Our Reference: SYD12/00976/02 (A8060473)
DP&E Ref: SSD 5535

**CONSTRUCTION OF THE WAHROONGA ADVENTIST SCHOOL IN FOUR STAGES AND NEW ACCESS ROAD AND SIGNALISED INTERSECTION
LOT 621 DP 1128314, LOTS 1 AND 2 DP 834960, LOT 1 DP 834961, AND LOT 4 DP 8349767,
FOX VALLEY ROAD, WAHROONGA**

Roads and Maritime has reviewed the submitted application and raise no objection to the Application. Roads and Maritime has the following conditions to be included in any consent issued by the Department of Planning and Environment:

DESIGN LAYOUT
WAHROONGA
TCS No. 3210

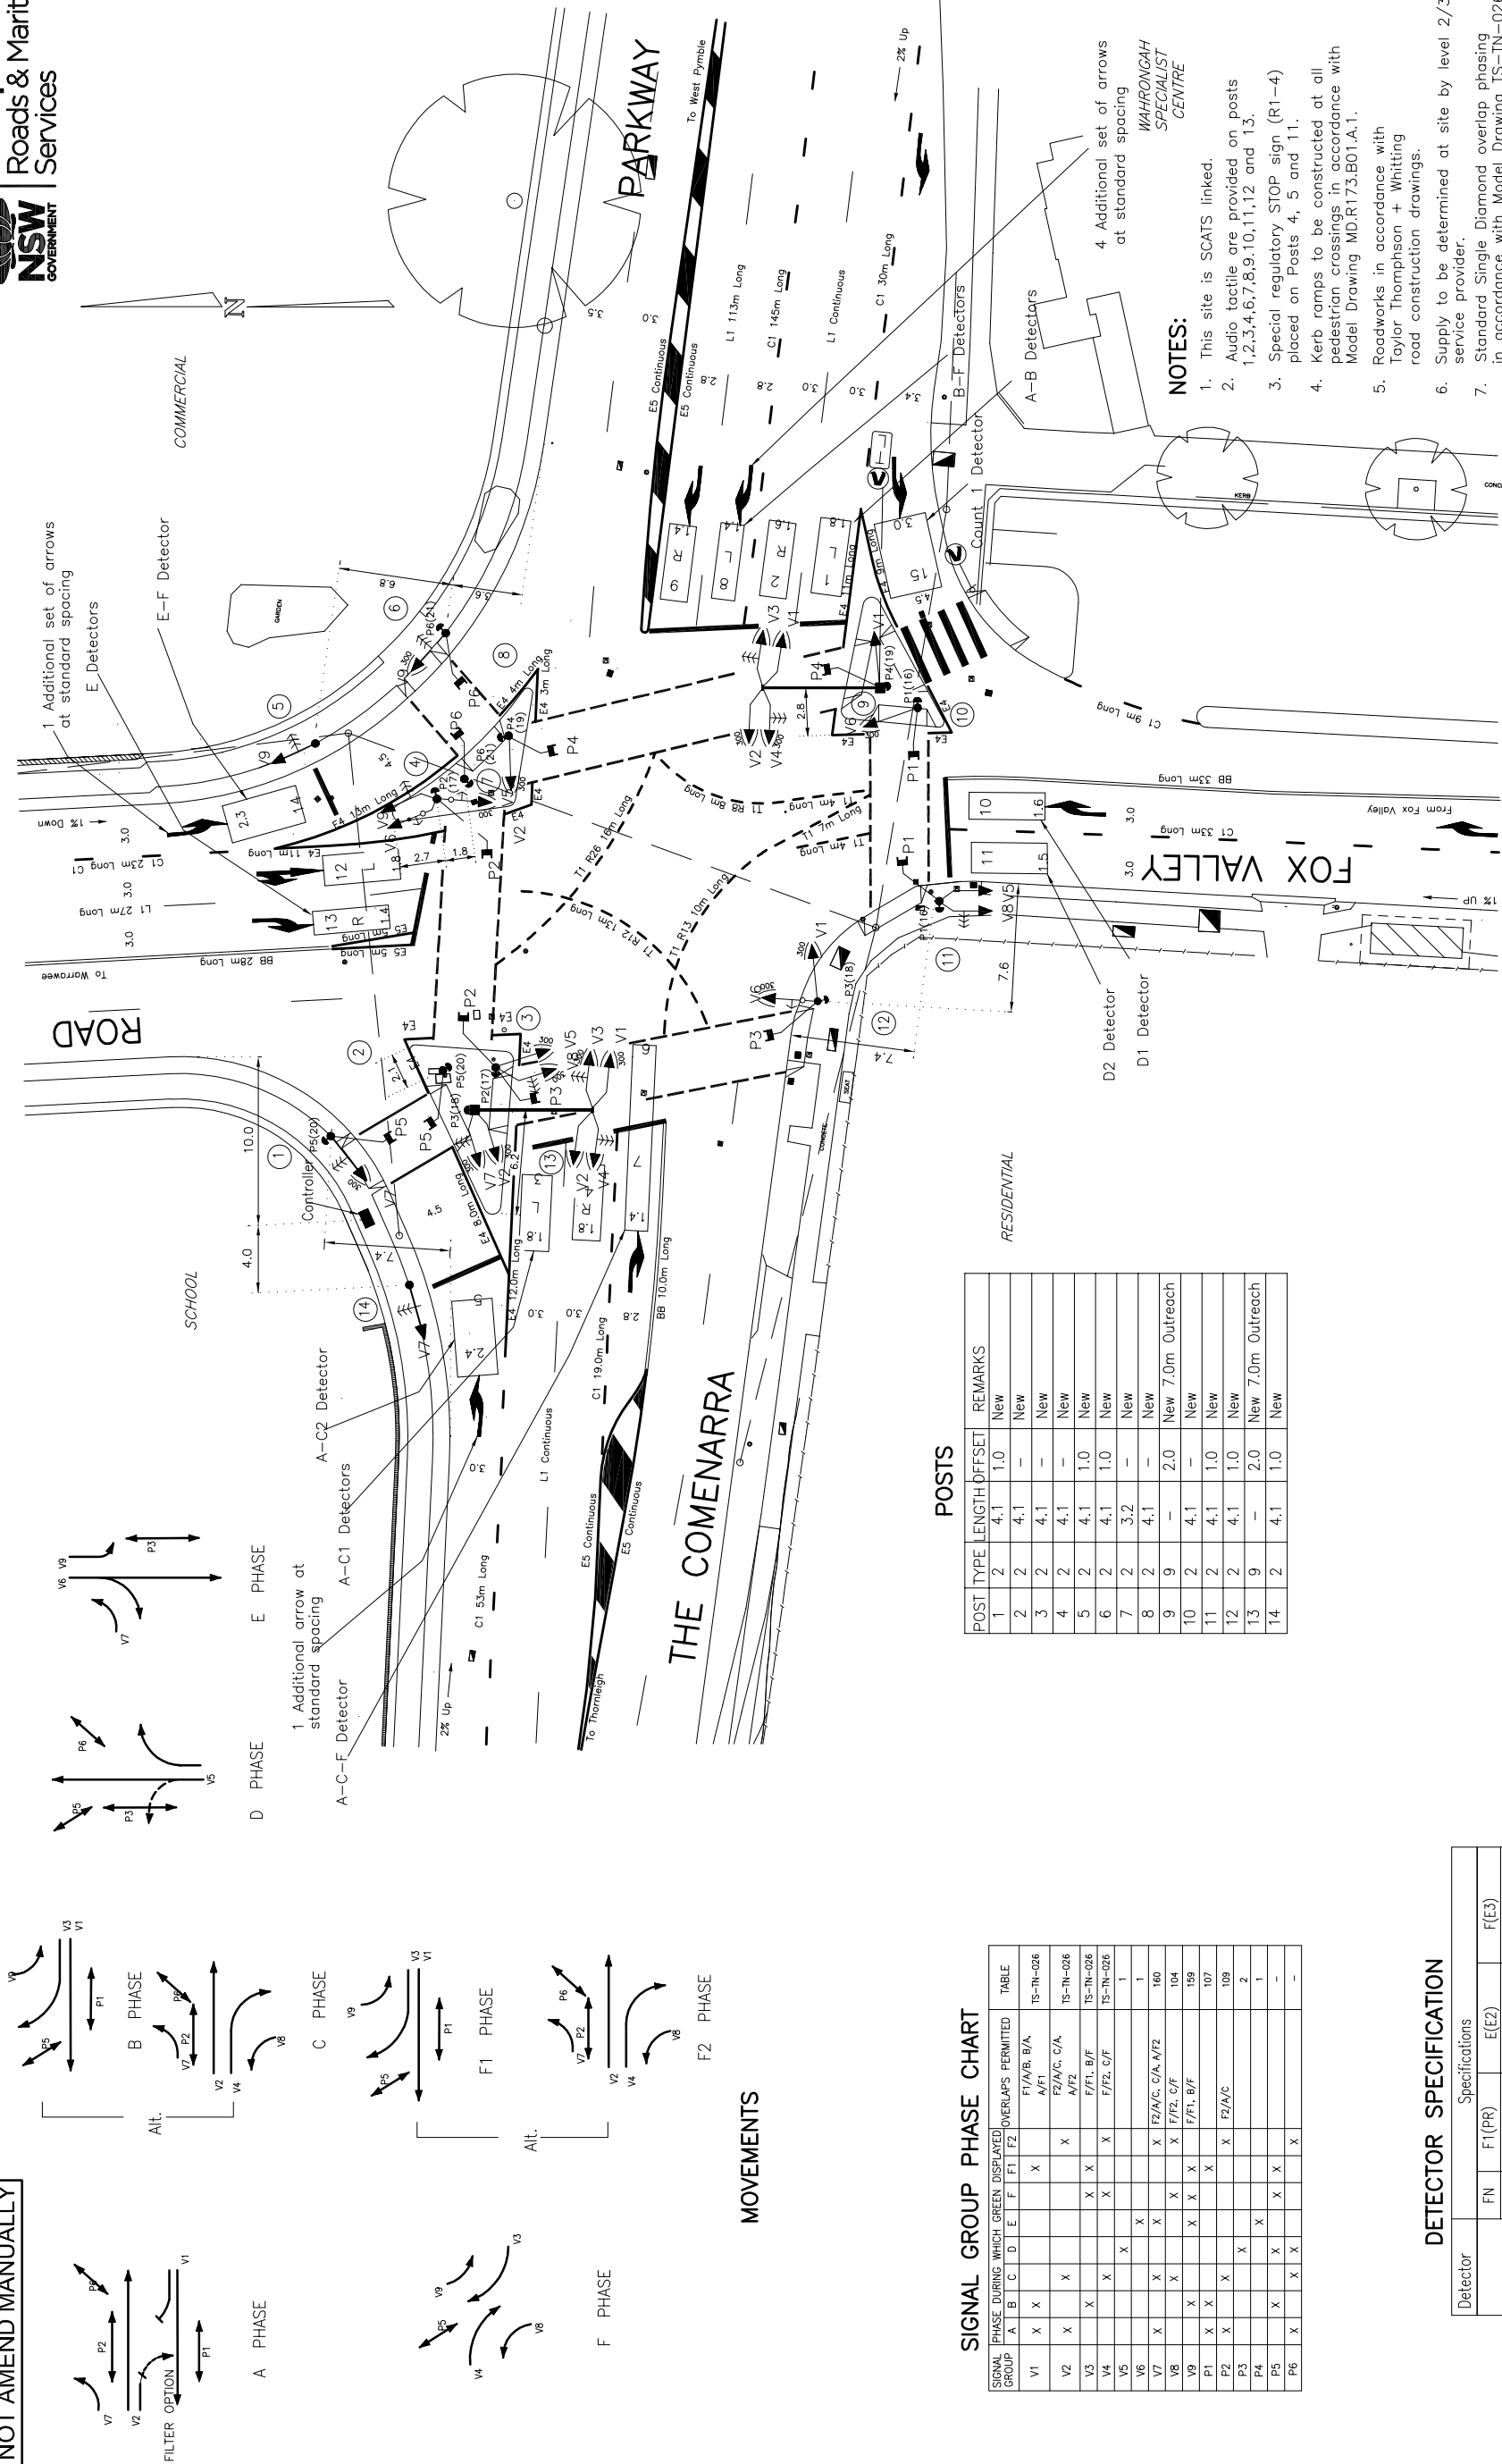
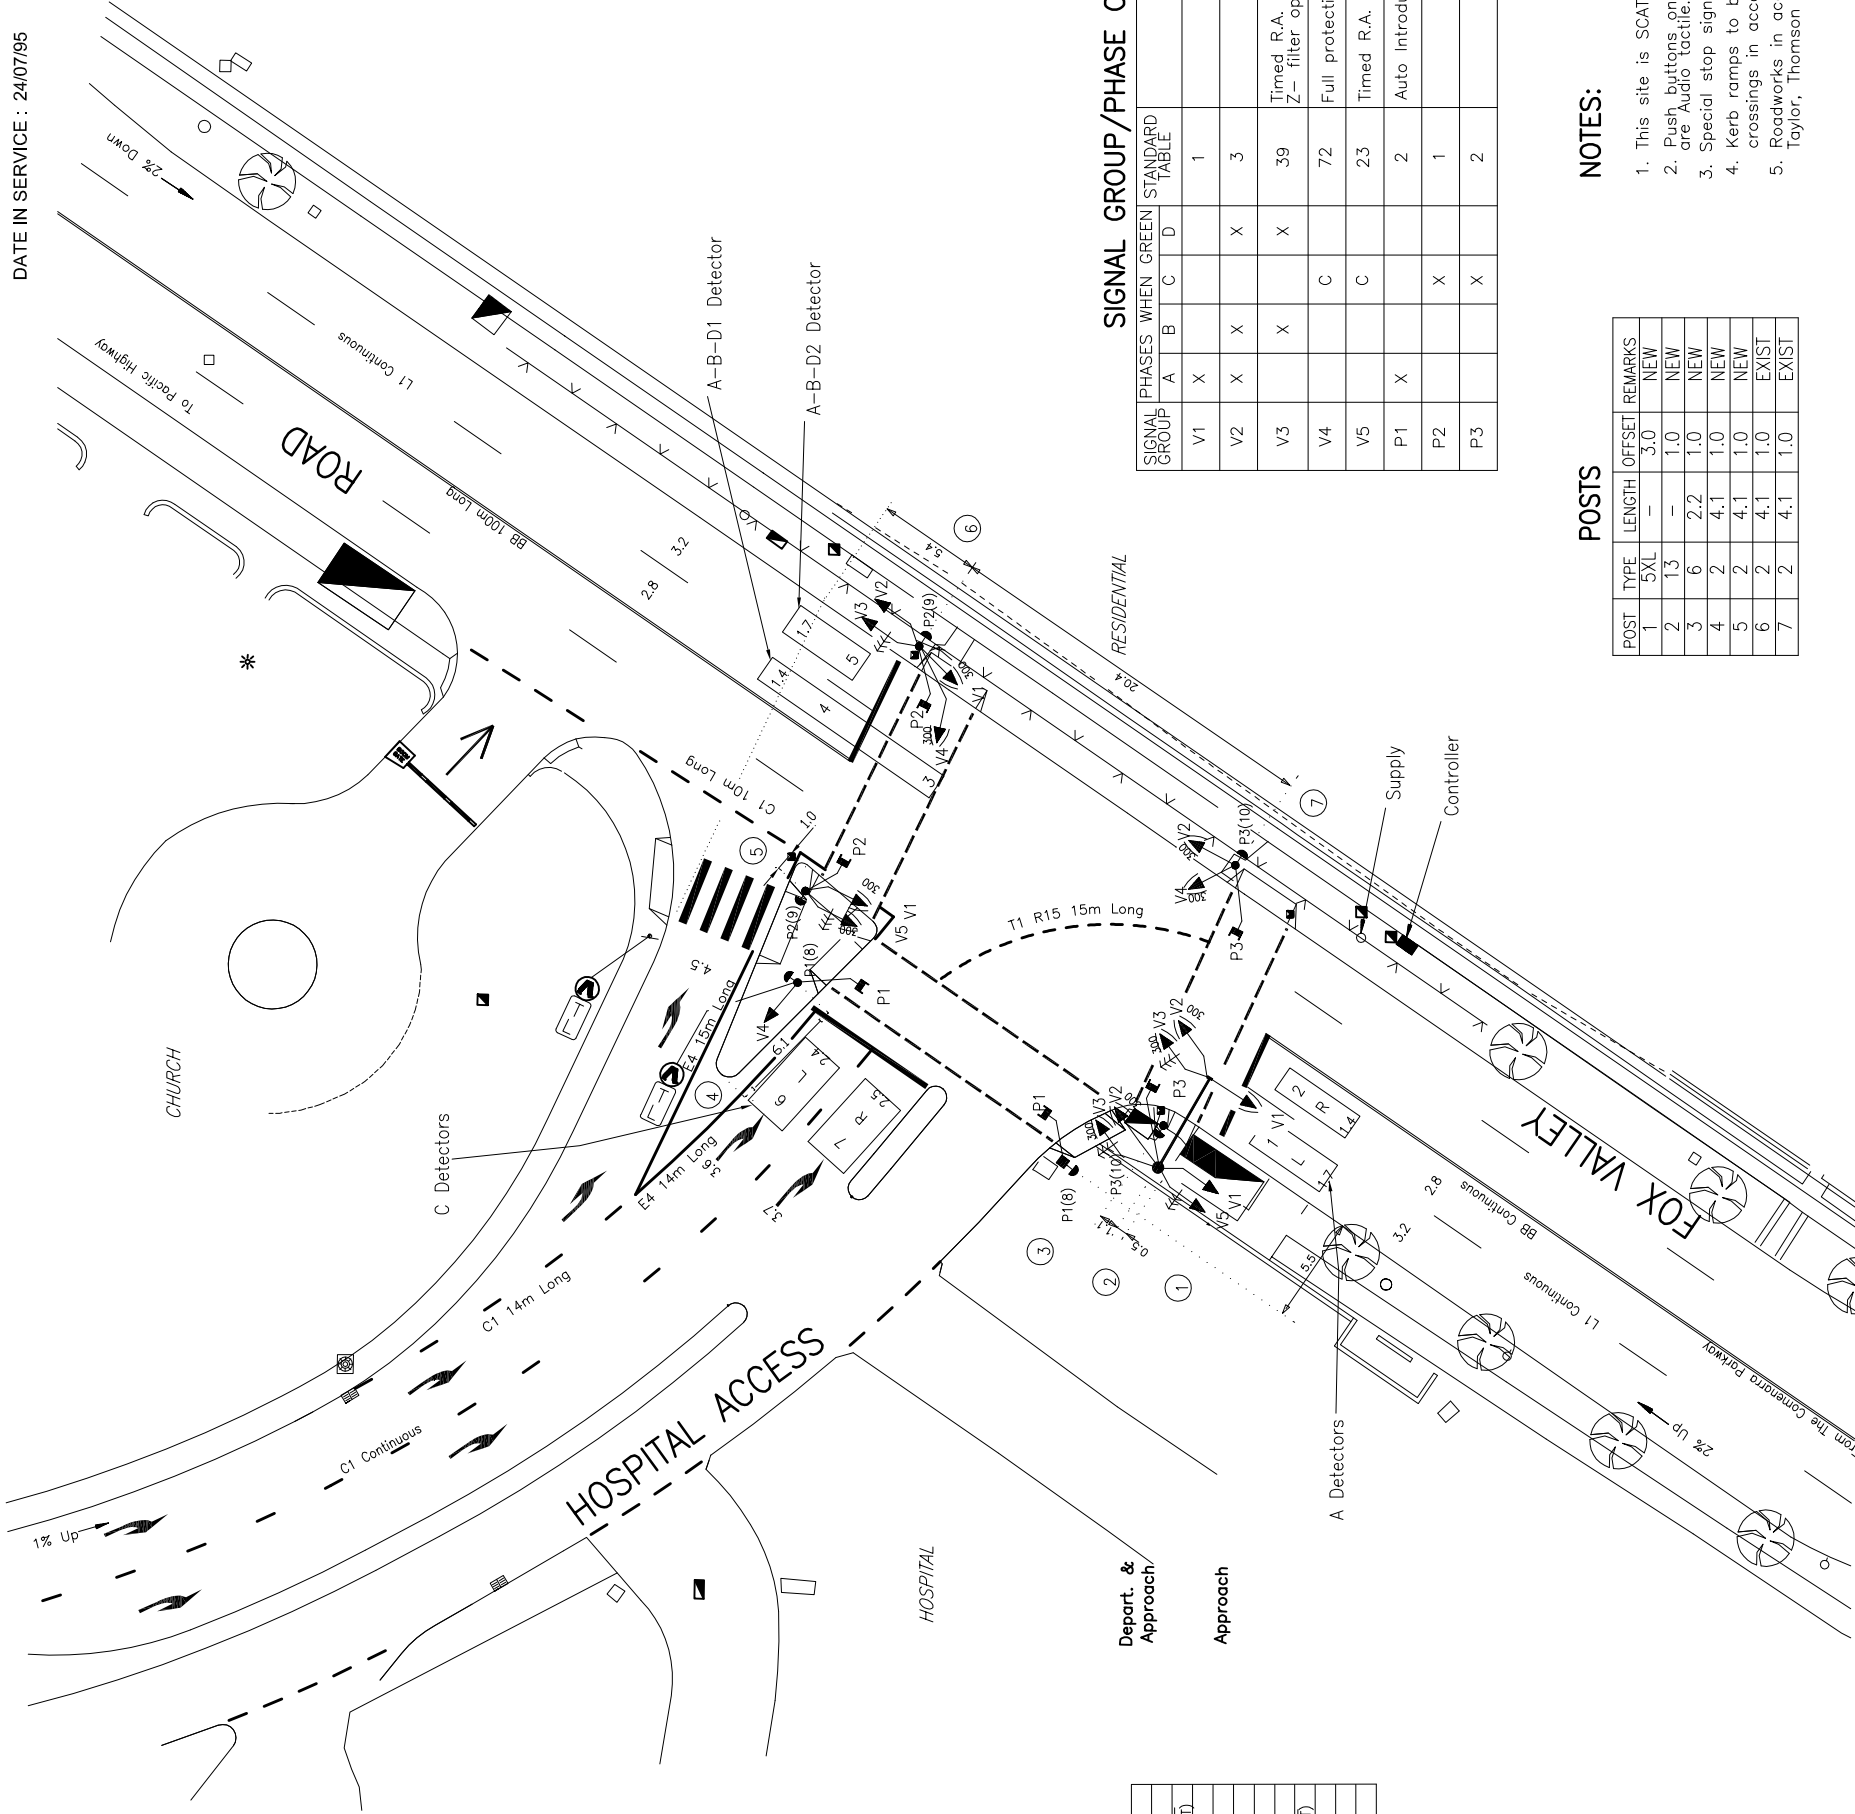
6. The provision of the new traffic control signals and civil works at Fox Valley Road and new school access road intersection shall be designed to meet Roads and Maritime requirements and endorsed and drawn by a suitably qualified practitioner. The design requirements shall be in accordance with Roads and Maritime Traffic Signal Design Manual and other Australian Codes of Practice.

Roads and Maritime fees for administration, plan checking, civil works inspections and project management shall be paid by the developer prior to the commencement of works.
7. The certified copies of the civil design plans for the signalised intersection shall be submitted to Roads and Maritime for consideration and approval prior to the release of the Construction Certificate by Council and commencement of road works.
